# CITY OF ALBUQUERQUE

March 22, 2021

**RE: Lot 2 Block 1 Volcano Cliffs Unit 22 SAD 228  
8005 Alto Rey Ct. NW  
Grading and Drainage Plan  
Engineers Stamp Date: 10/19/2020 (D10D003N22)  
CO Certification Date: 3/11/2021**

TITLE: **GRADING AND DRAINAGE PLAN**

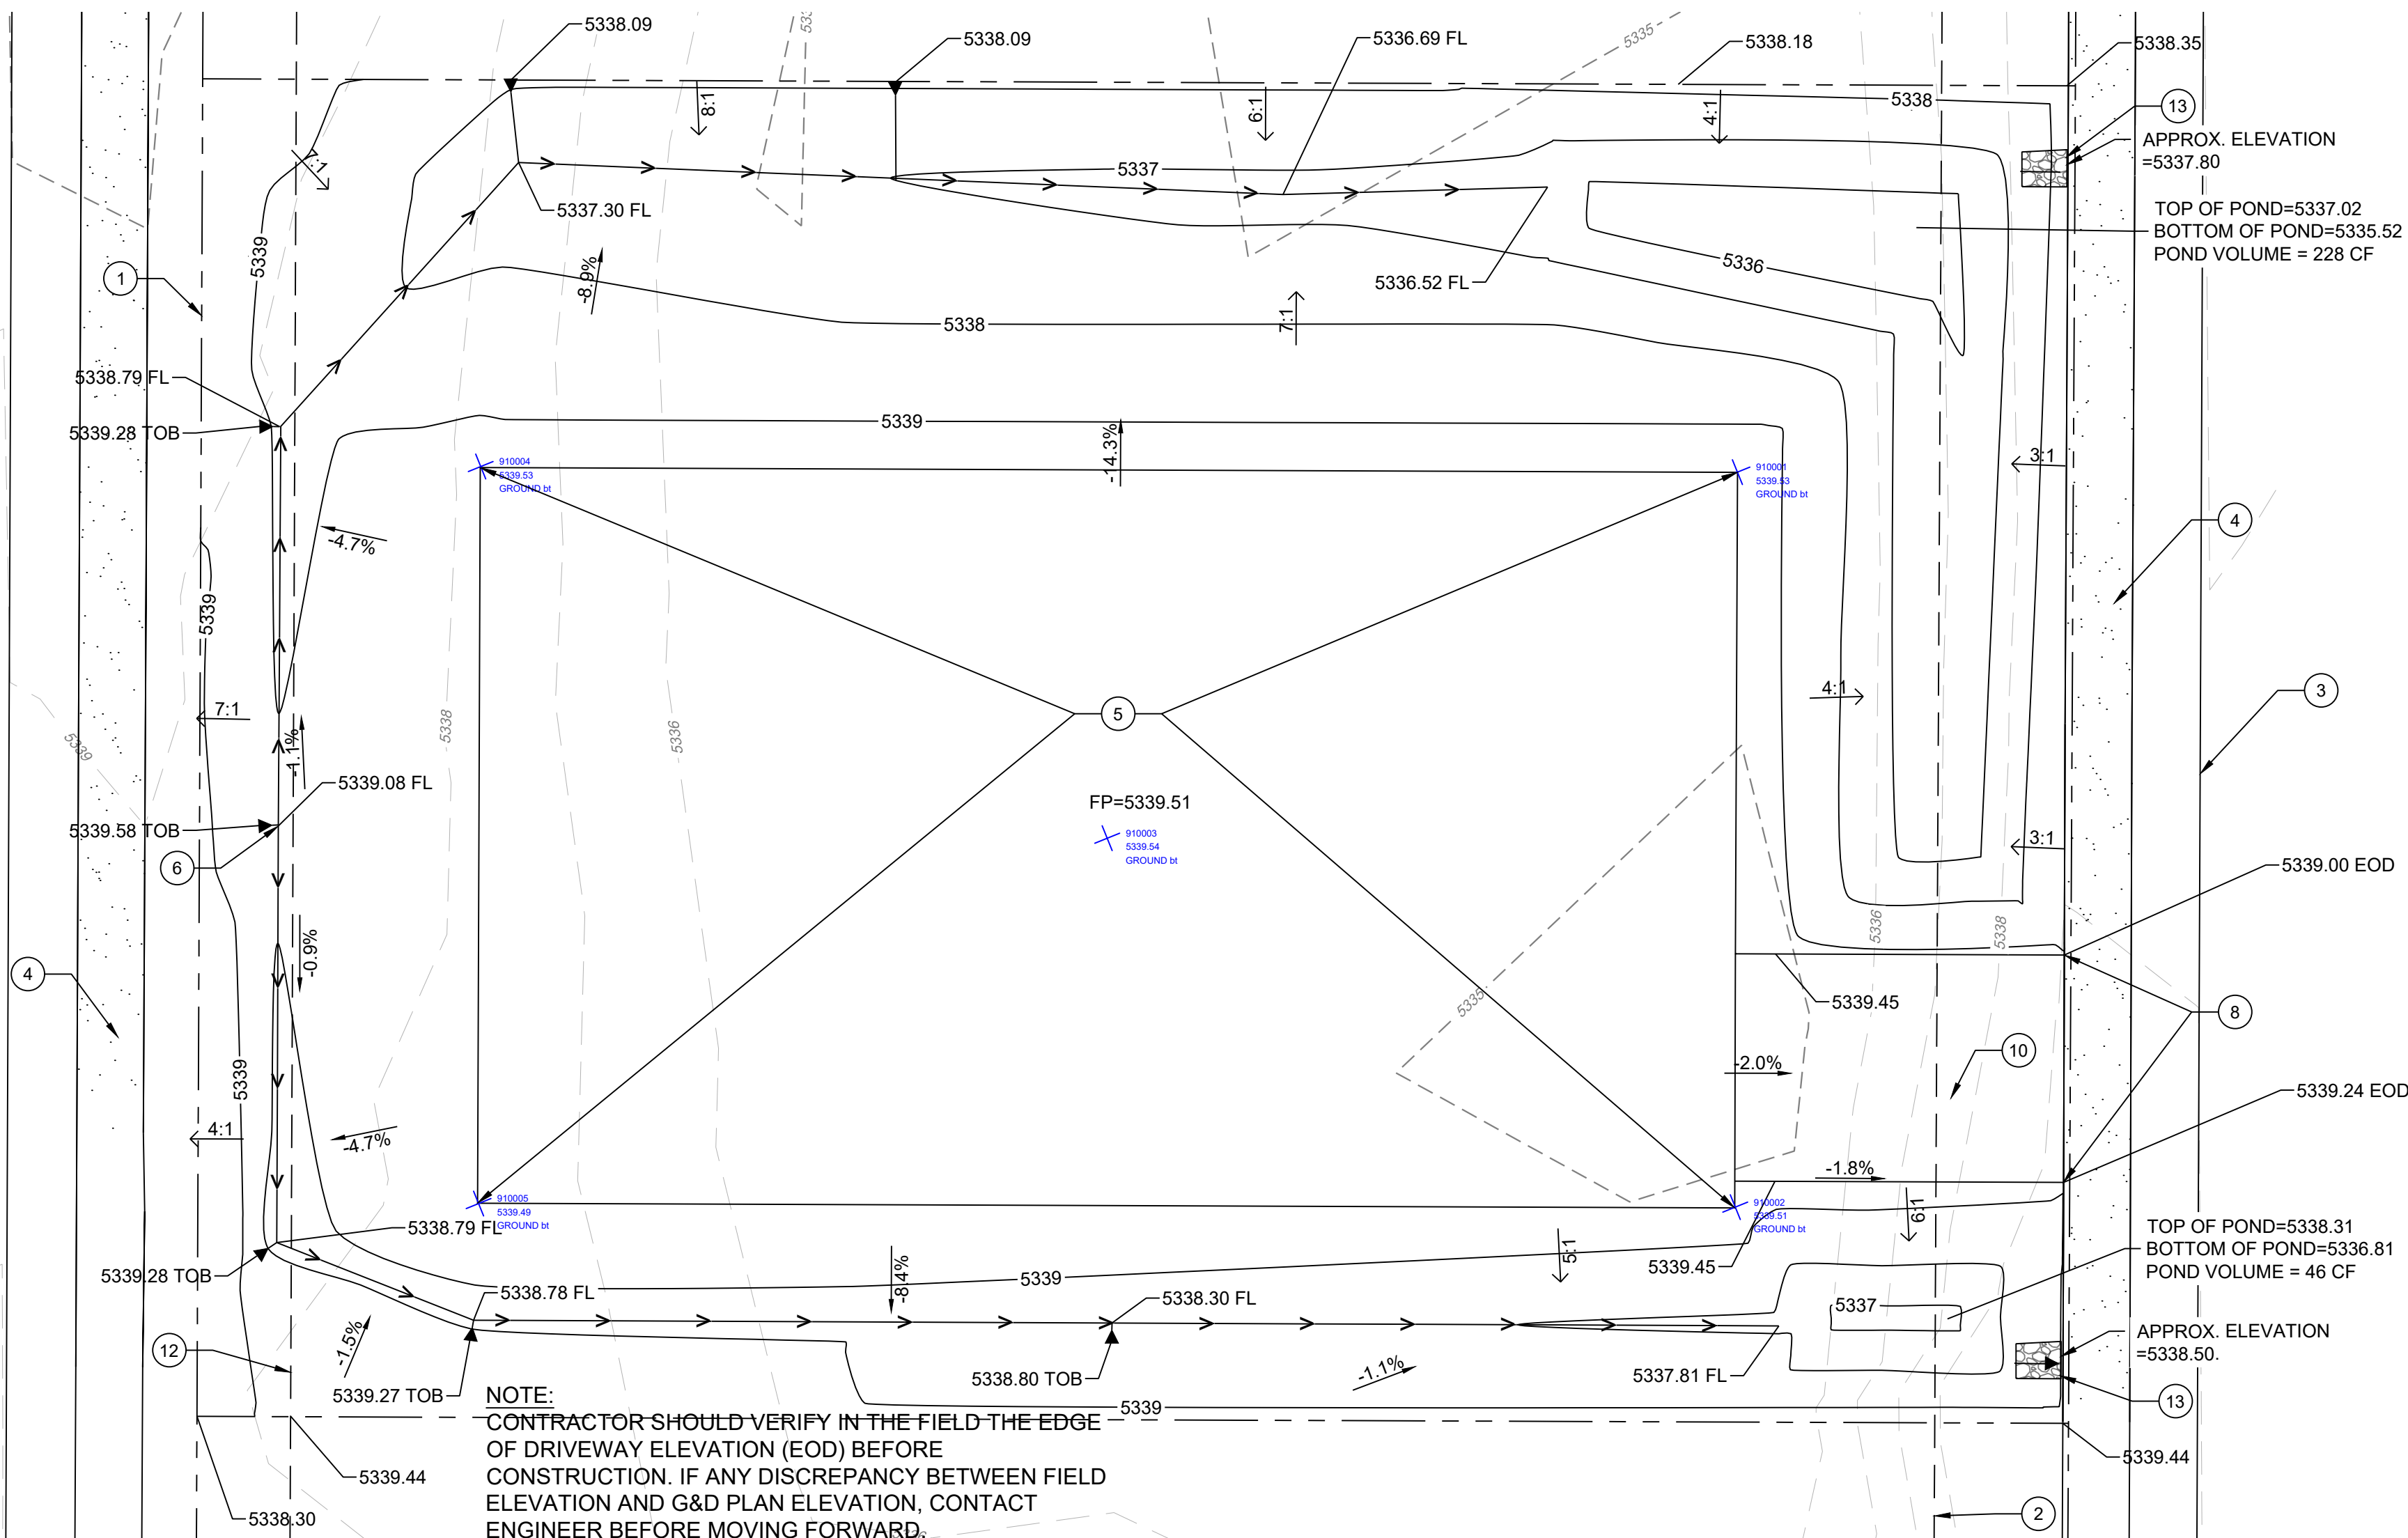
- Lot did not have an address, provide address
- Have all dirt ramps removed from the streets. Crusher fines or lumber are to be used for driving over a curb.
